CITY OF ALBUQUERQUE

March 27, 2017

**RE: Coors Pavilion Subdivision Lot 4 & Portion of Lot 5
9154 Coors Blvd
Grading Plan
Engineer's Stamp Date: 3/1/2017
Hydrology File: G11D069B**

Based upon the information provided in your submittal received 3/24/17, the Grading Plan is approved for Site Development for Building Permit.

CITY OF ALBUQUERQUE  
PUBLIC WORKS DEPARTMENT  
ENGINEERING DEVELOPMENT GROUP  
**COORS PAVILION SUBDIVISION**  
**LOT 4 & PORTION LOT 5**  
**GRADING & DRAINAGE PLAN**

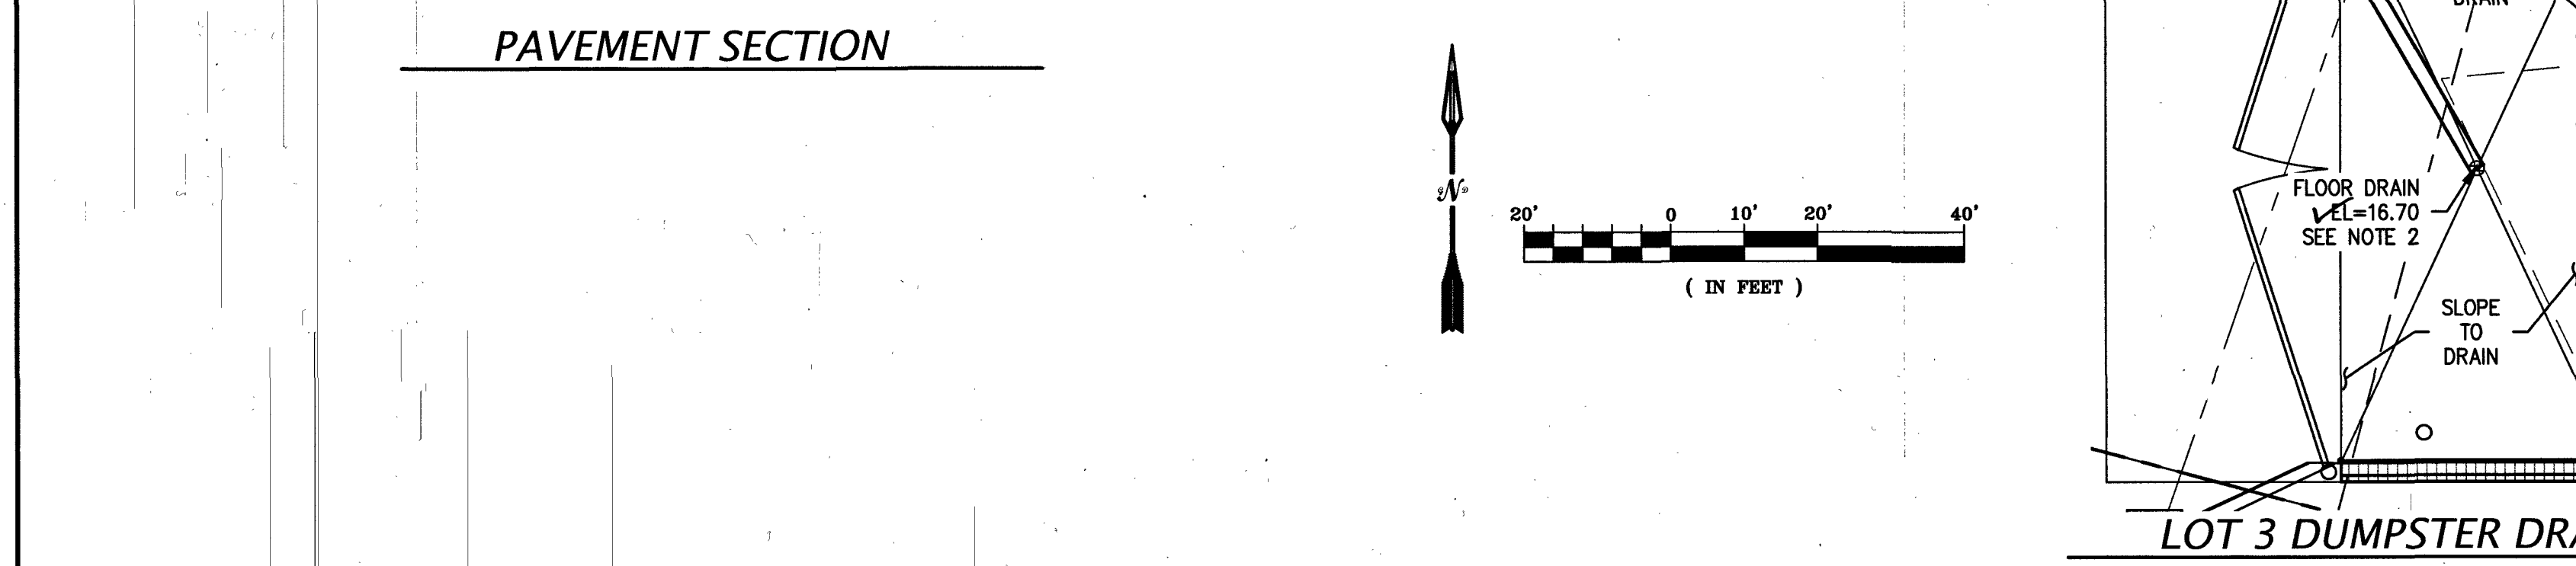
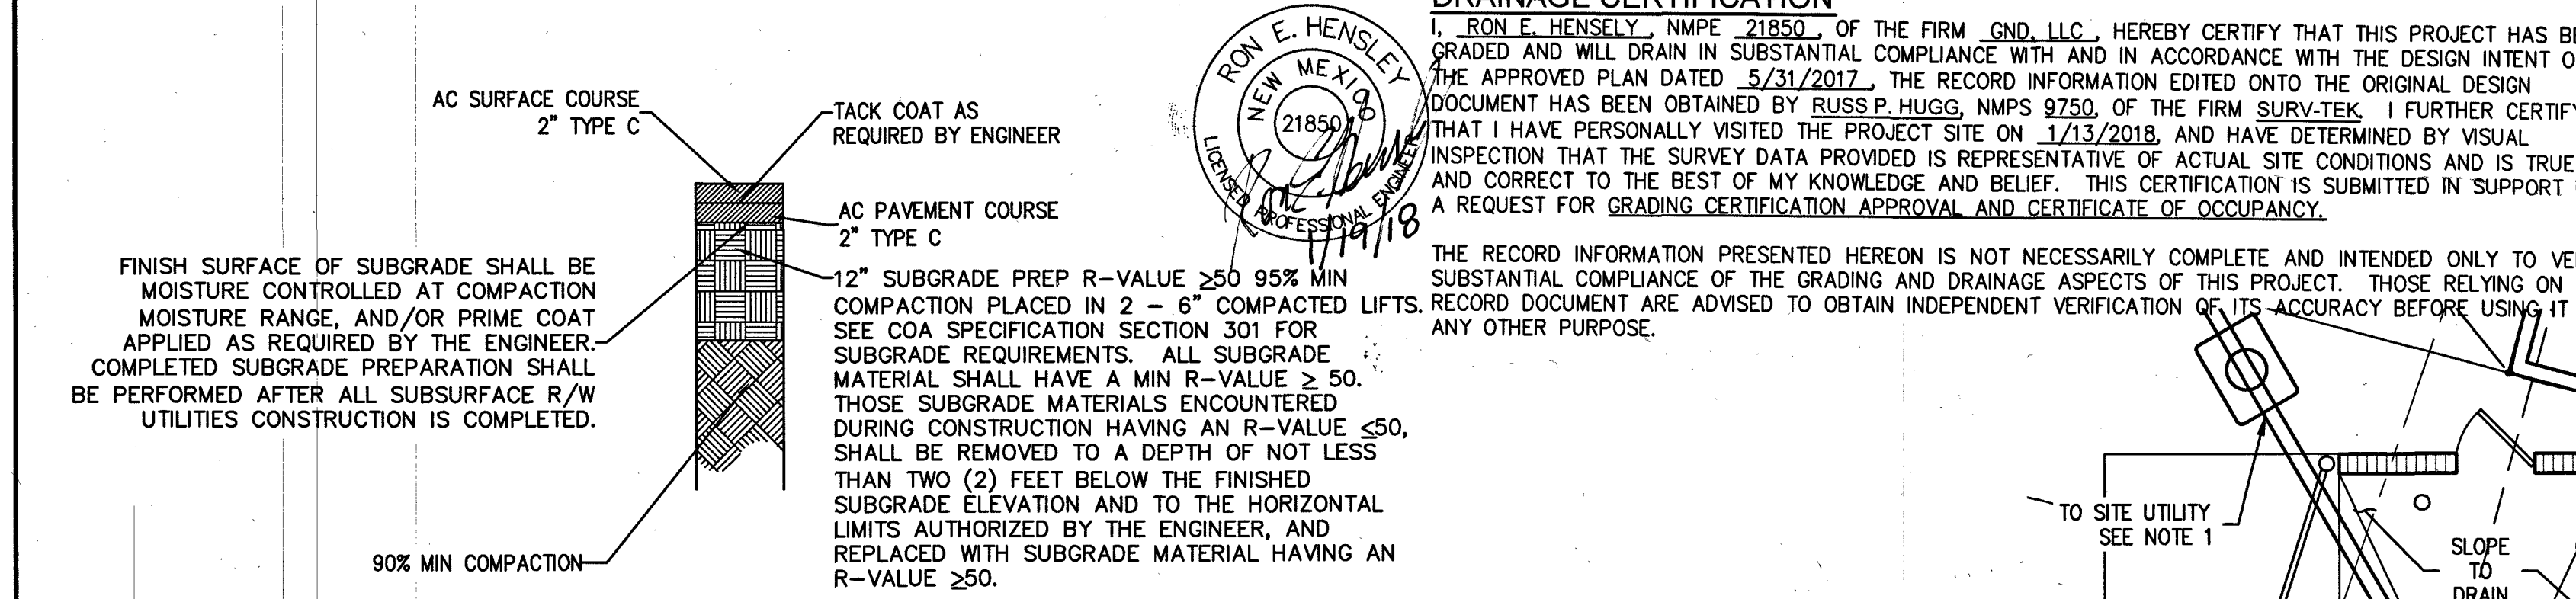
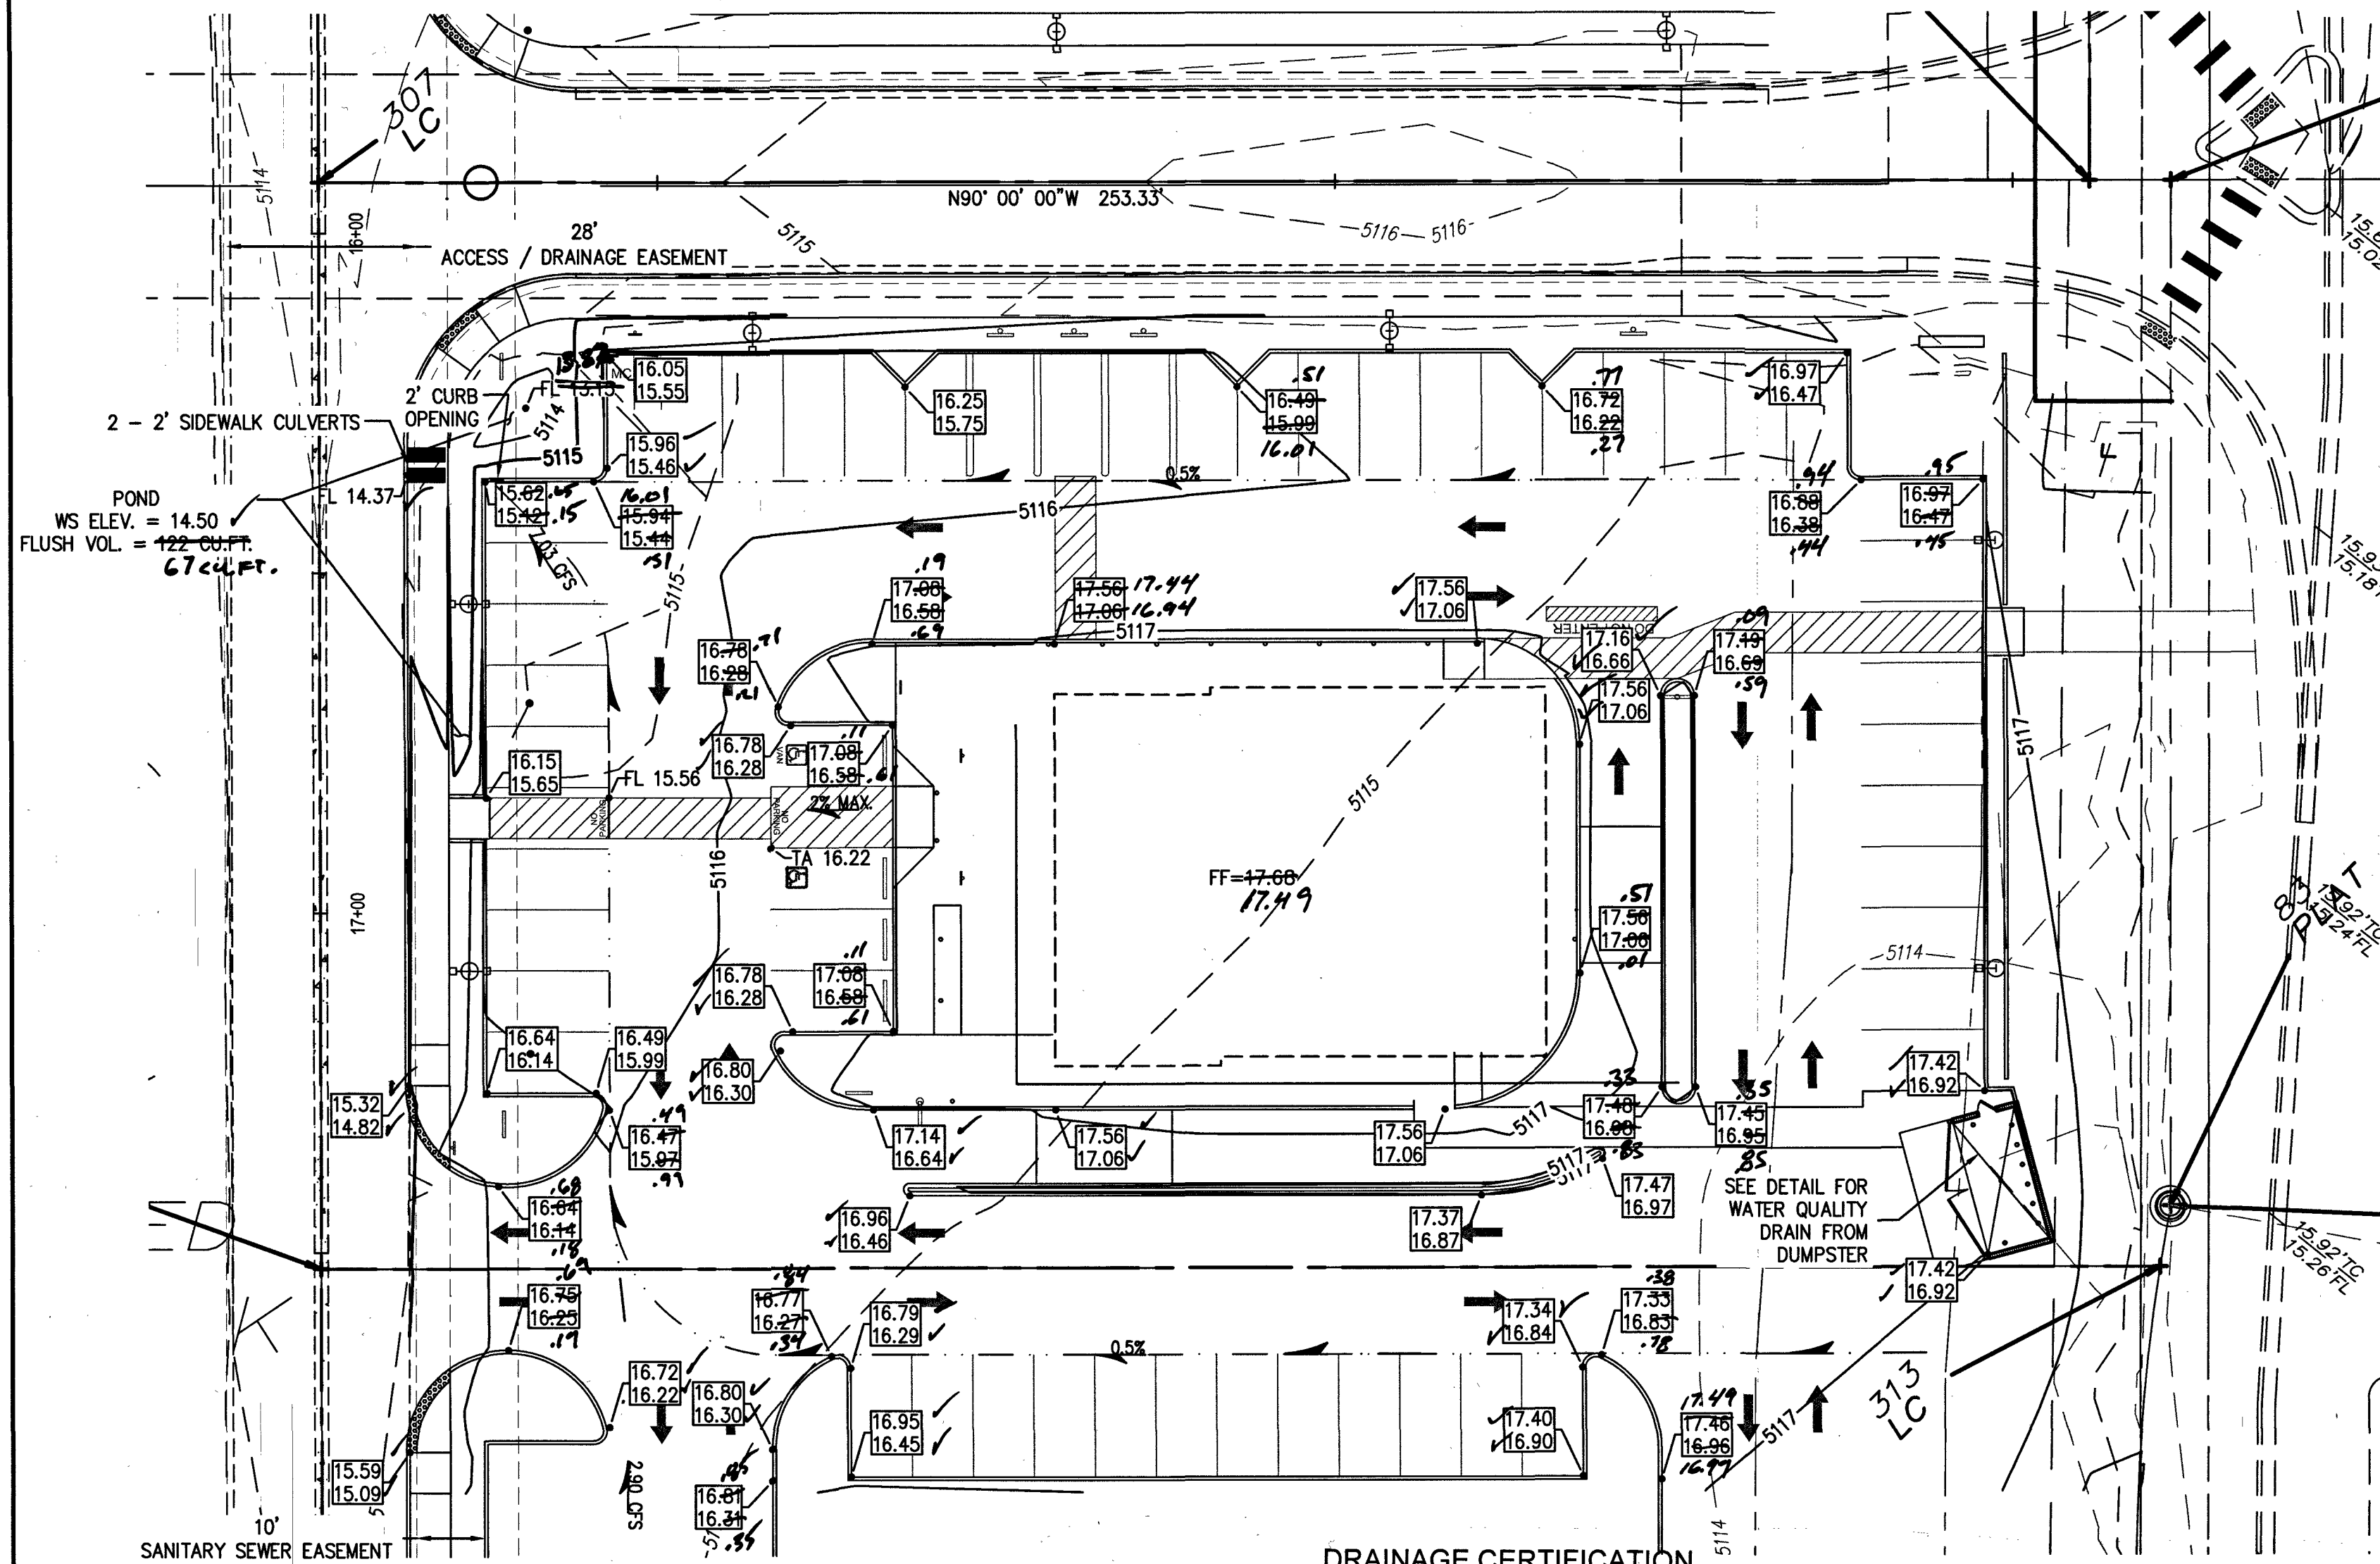
1. Prior to Final Plat, a cross-lot drainage easement will be required for Lot 4 for the benefit of Lot 5.
2. Are either of these lots being developed as restaurants? If so, provide trash enclosure containment and drainage through a grease trap and into the sanitary sewer.
